**KIRKLEES METROPOLITAN COUNCIL
INVESTMENT & REGENERATION SERVICE**

**DELEGATED DECISION TO DETERMINE APPLICATIONS FOR
NON-MATERIAL AMENDMENTS**

Reference No:	2025/NM/93365/E
Site Address:	Cross Rink Street, Batley, WF17 6BH
Description:	Non material amendment to previous permission 2009/93382 for erection of retail development
Recommending Officer:	Katie Chew

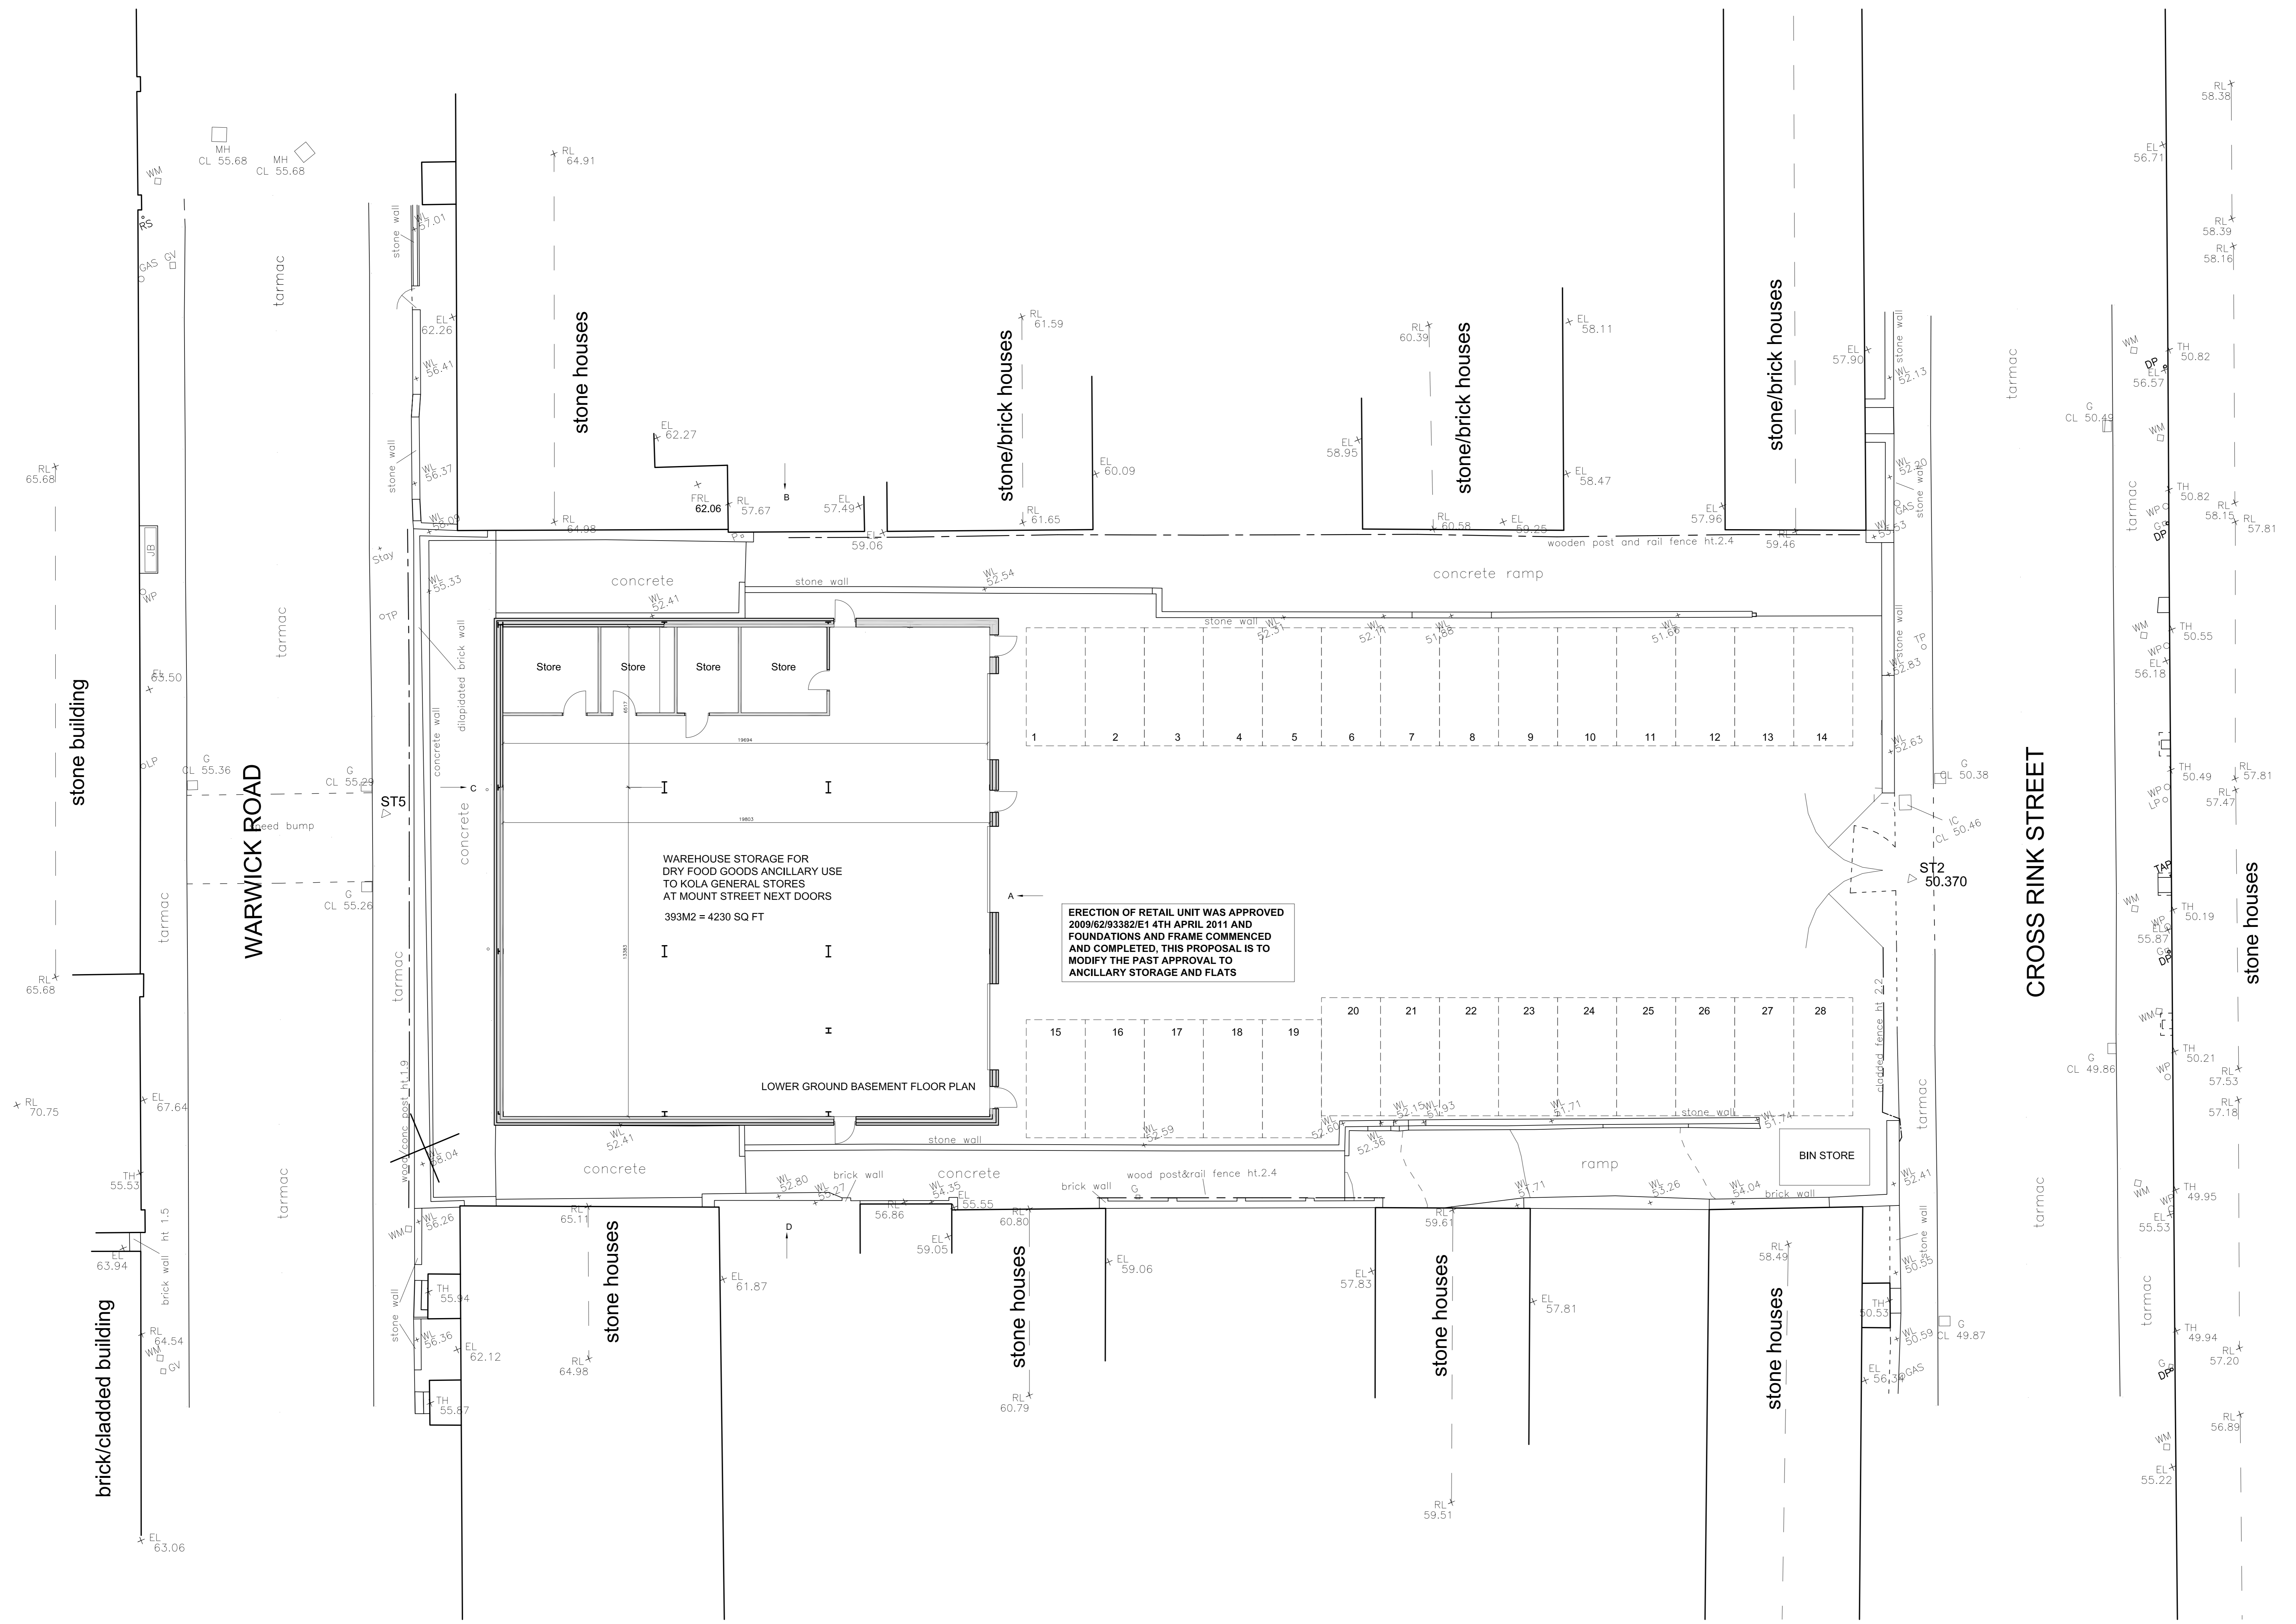
- No details have been provided in respect of materials and therefore Officers cannot confirm whether these are to be as approved, or not.
- Alterations to the originally approved access with a smaller, gated entrance shown on the submitted block plan, than previously approved.
- Parking numbers have changed with an increase of 2 spaces, due to the loss of 2 originally approved disabled spaces.
- Finally, the overall use of the site is proposed to be changed from a retail unit with storage and staff facilities, to 10 flats and warehouse storage.
